Your Ref: OWQC24450
Our Ref: EP/41/19/PL
Please ask for:
Mr A Wood

1st October 2019

Loft conversion to existing flat.
128 Sea Road East Preston

Drawing Number: 1204.01.b

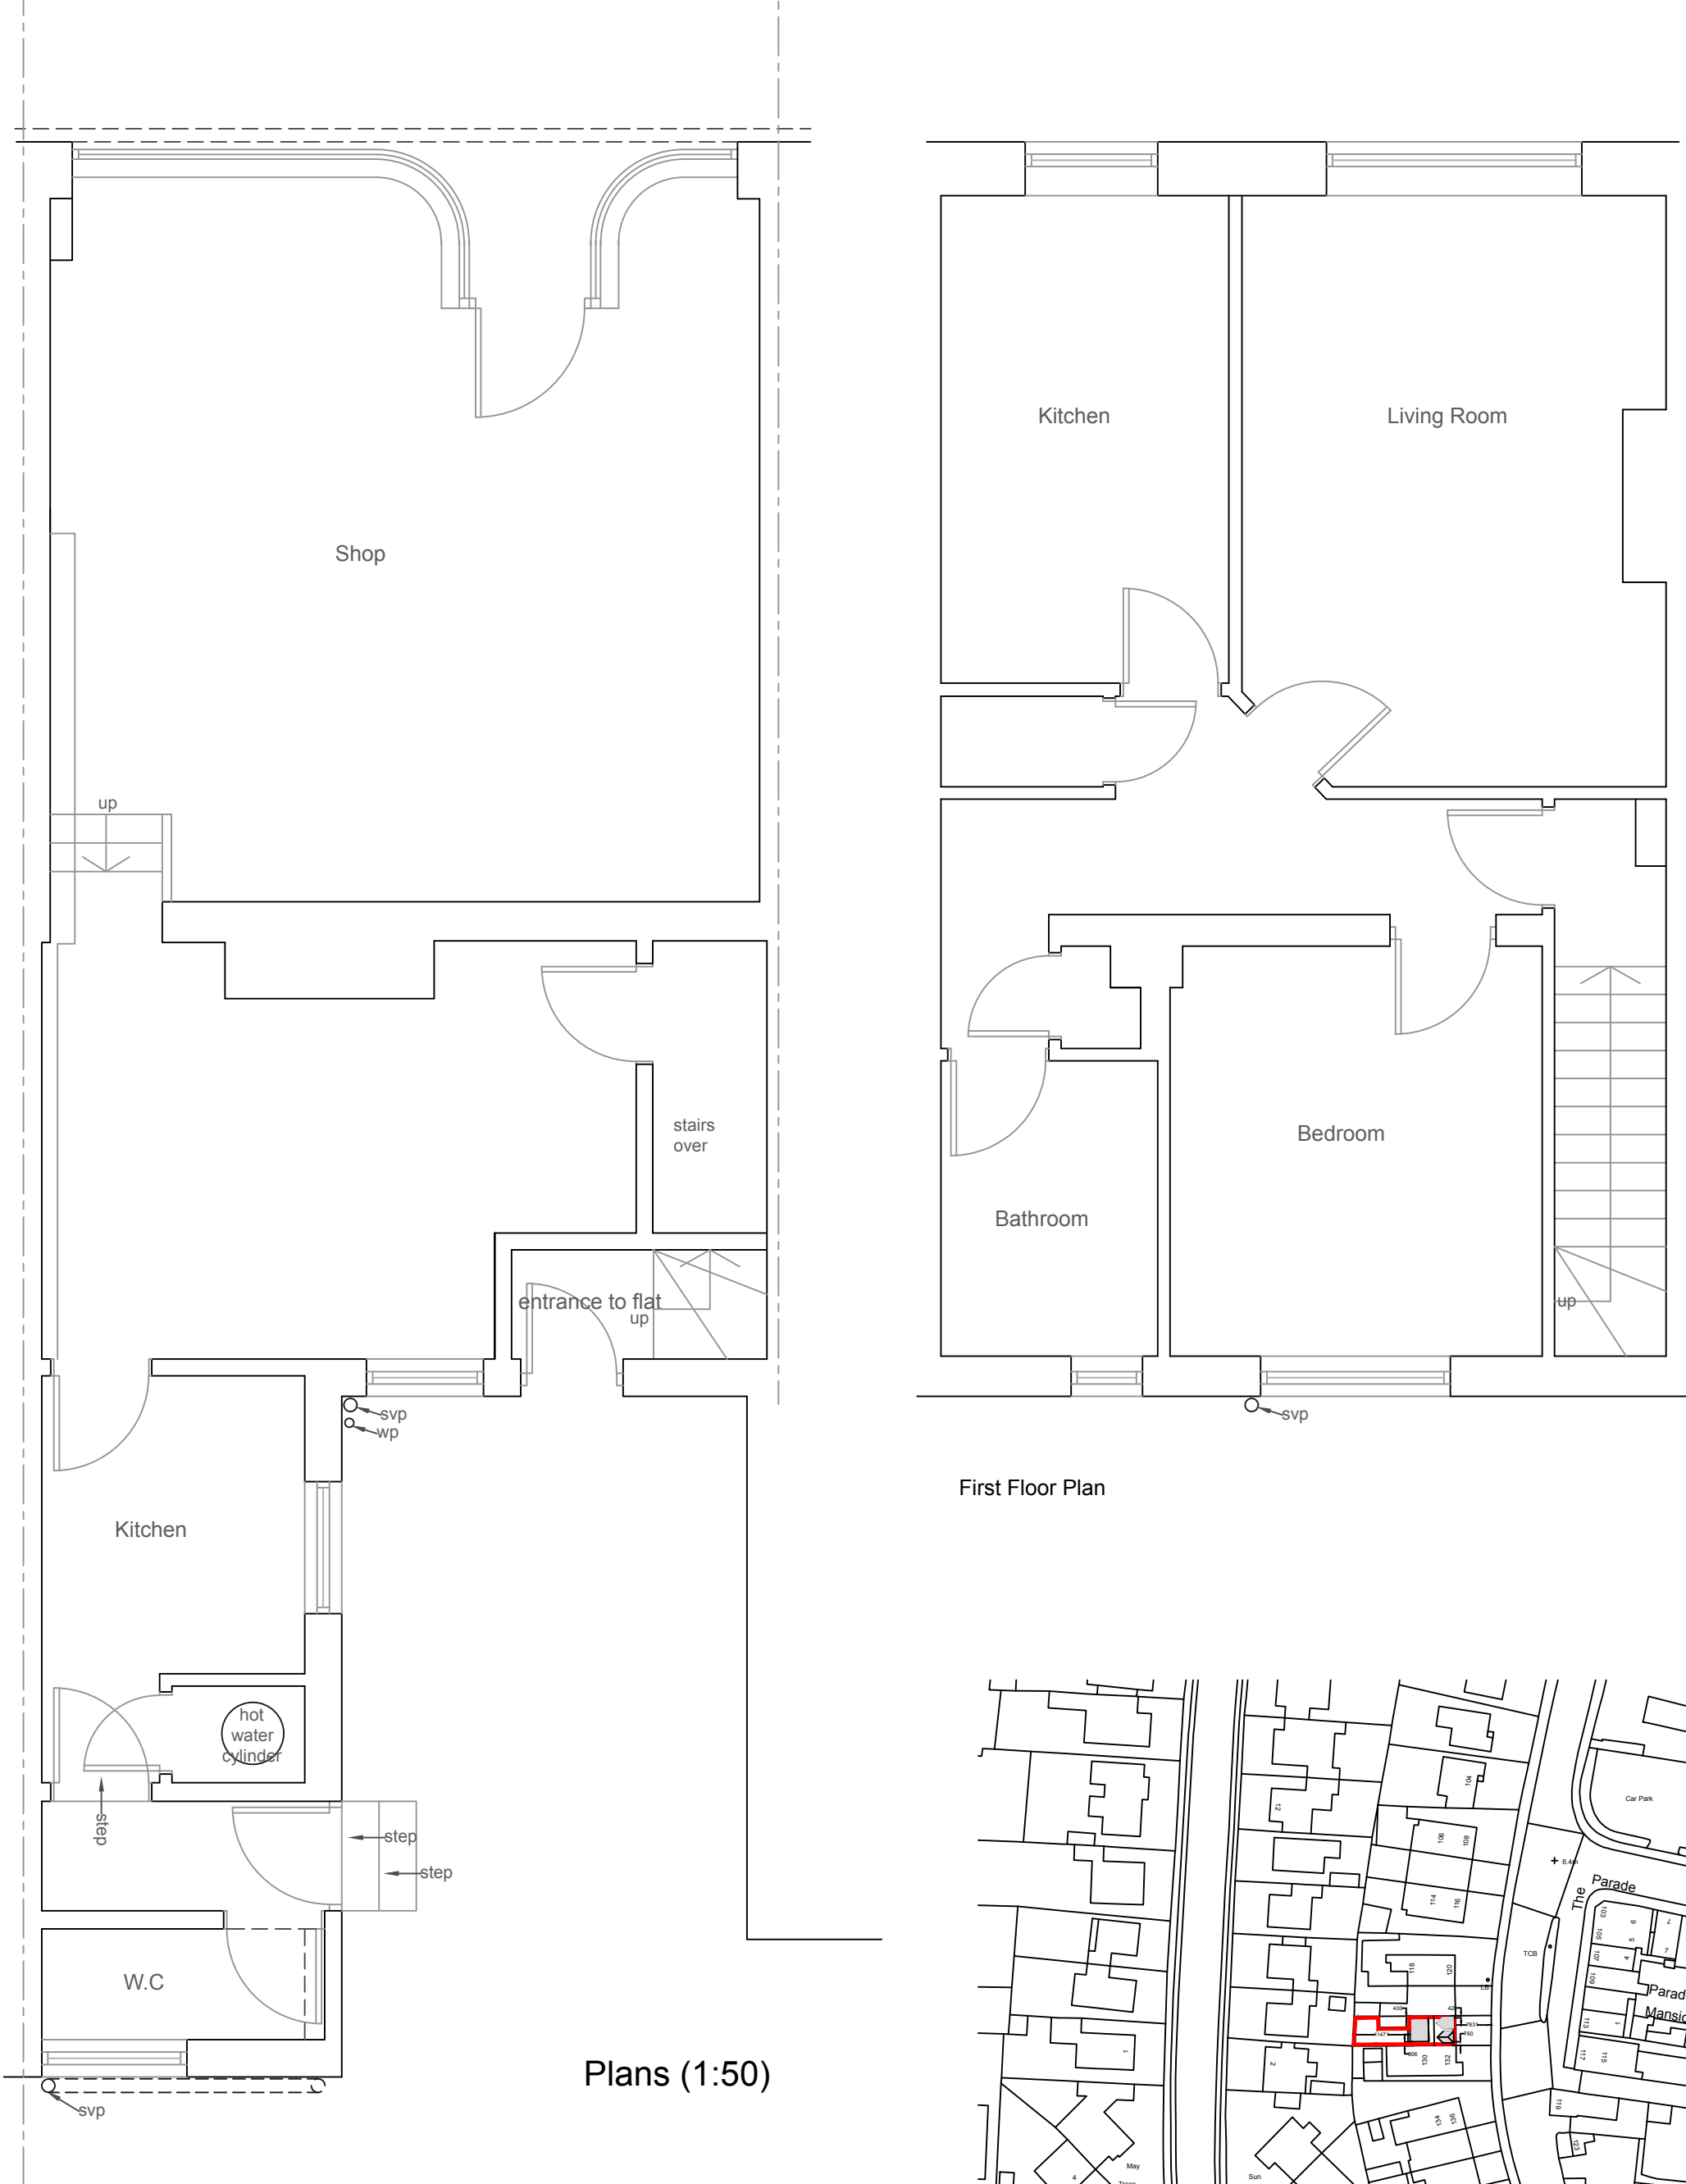
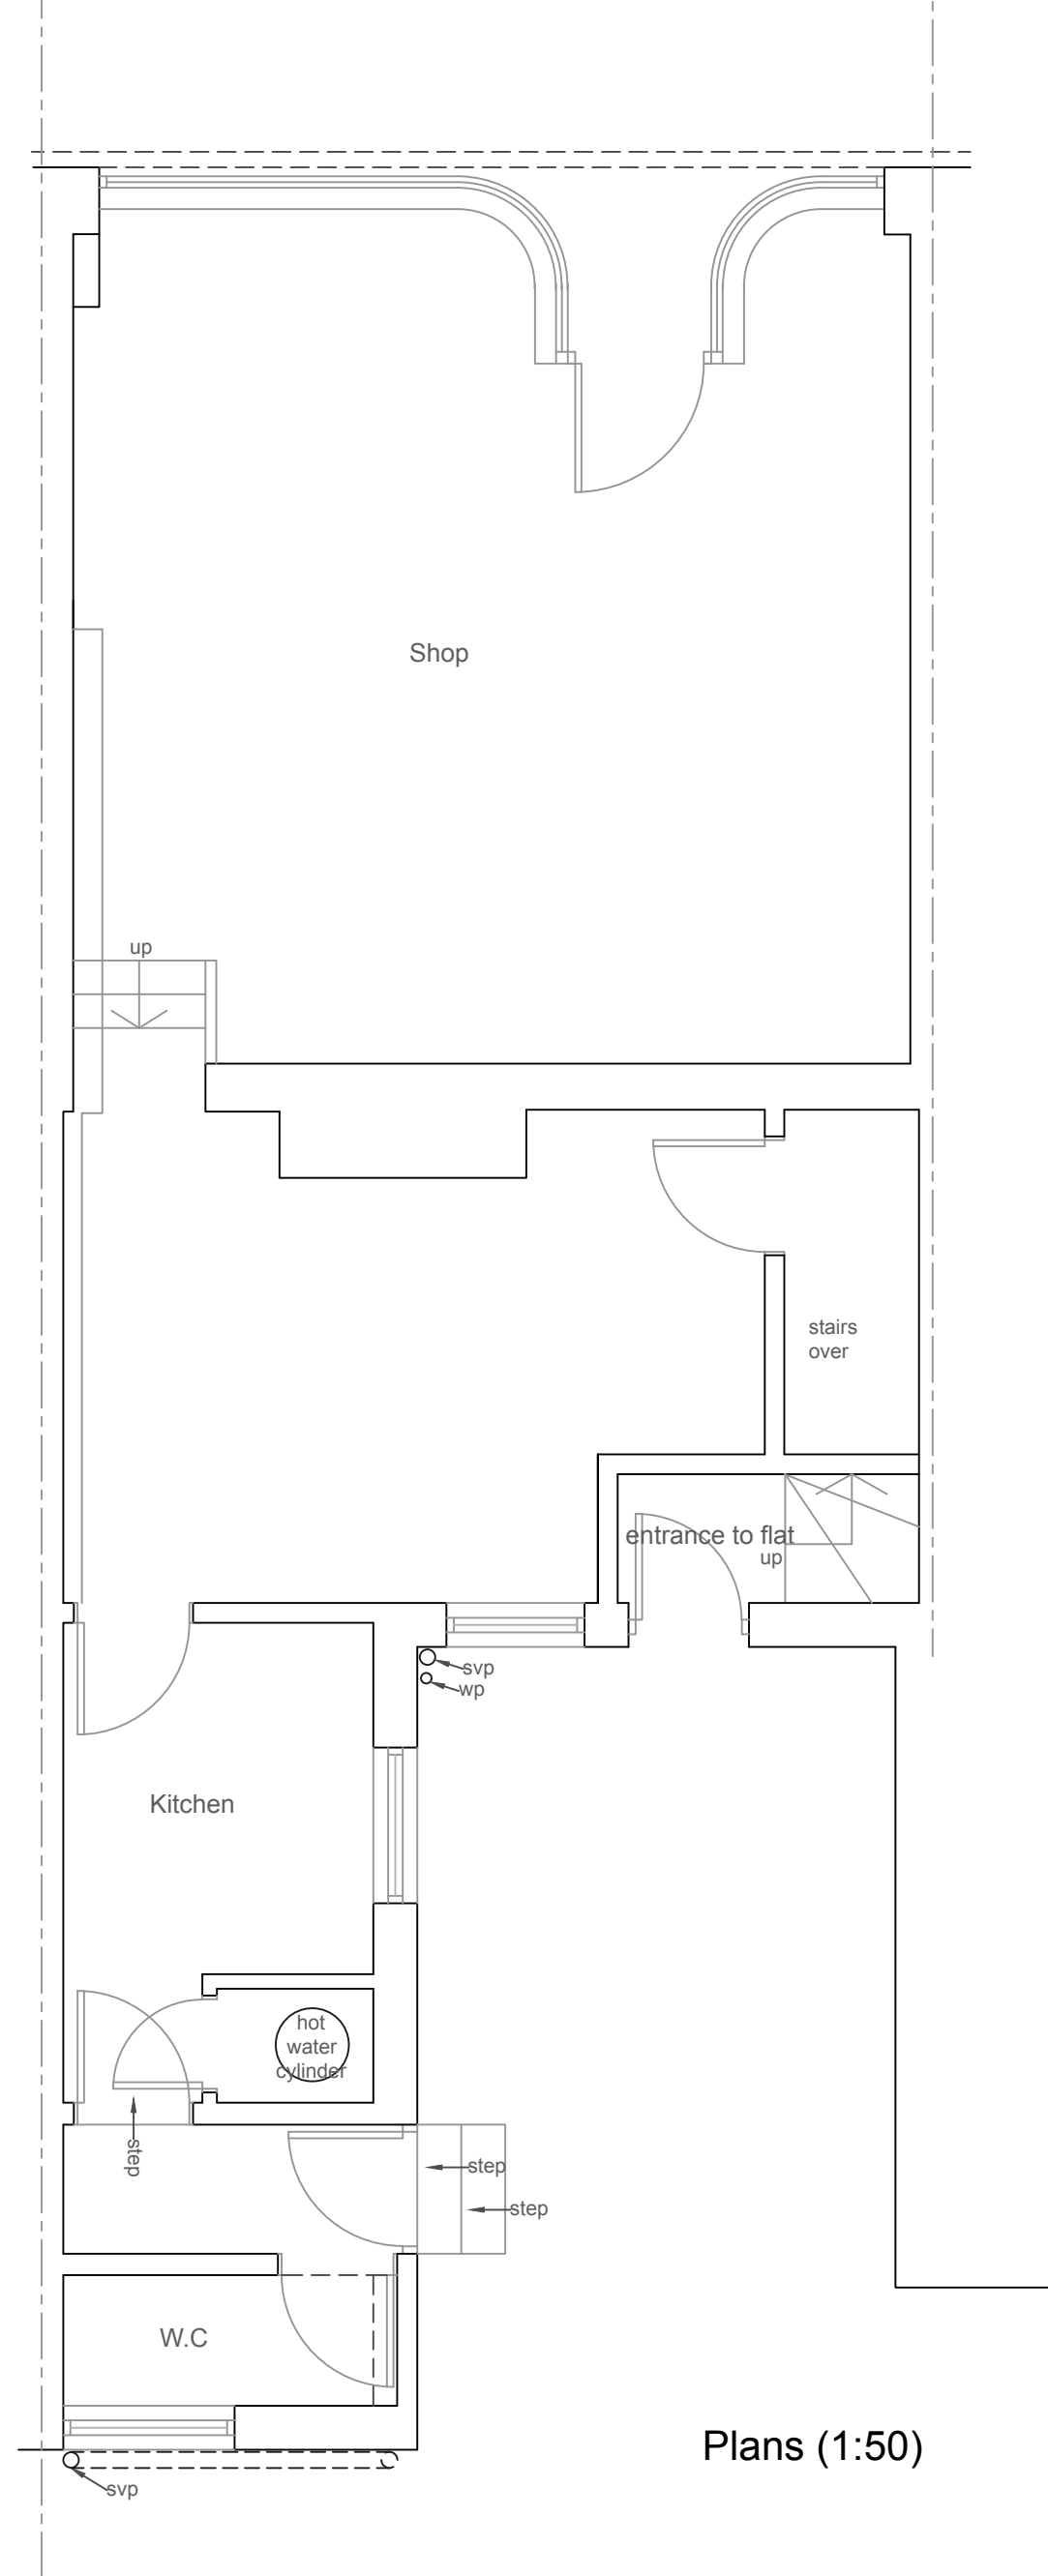
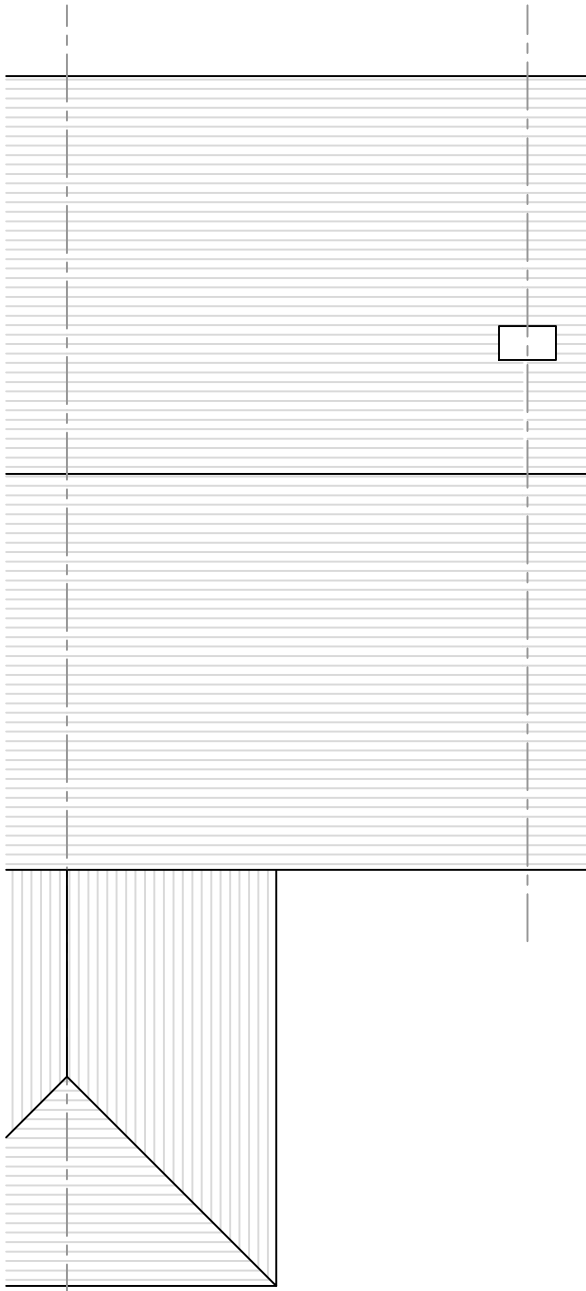
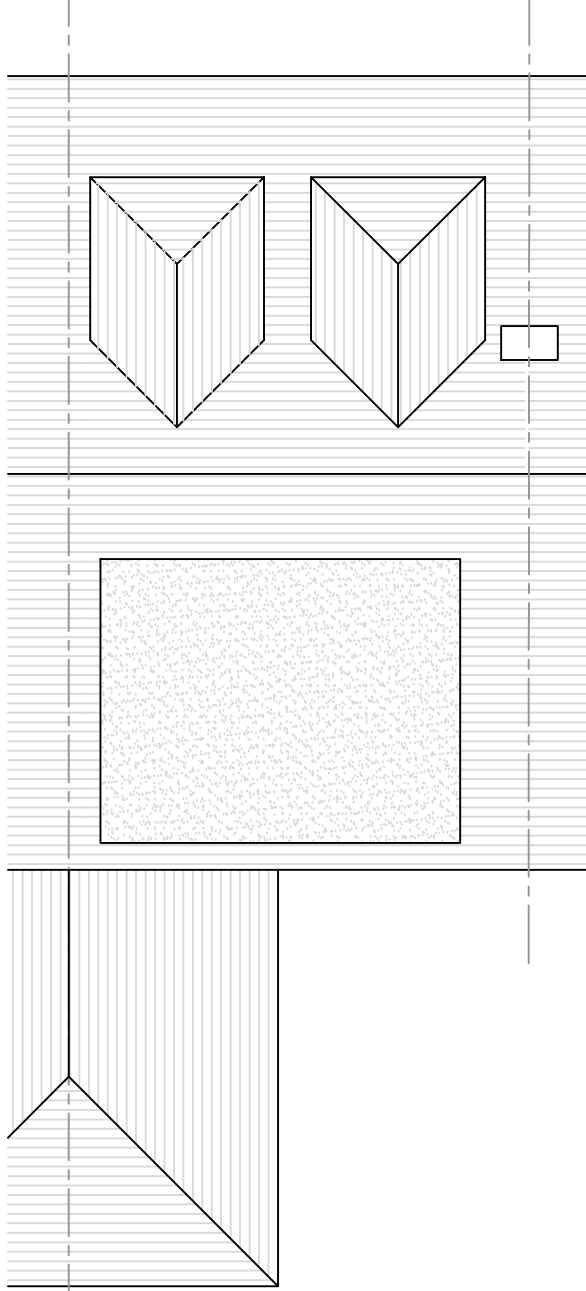
The Planning & Licensing Committee of this council considered revised plans for this Application at its meeting on Monday, 23rd September.

The committee continues to object to the installation of any arrangement of front dormer(s) at this property as such will have a negative impact upon this almost unchanged streetscene. This would be contrary to Policy 1 of the East Preston Neighbourhood Plan section 4.18 of which states, Preservation of the street scene is important to protect the character of the village.

The proposed front dormer(s), by virtue of design, size and prominent location would have an unacceptable impact upon the character and appearance of the host dwelling and parade of shops as well as that of the immediate locality contrary to policies D DM1 and D DM4 of the Arun Local Plan.

The committee does not object to the proposed dormer to the rear of the property.
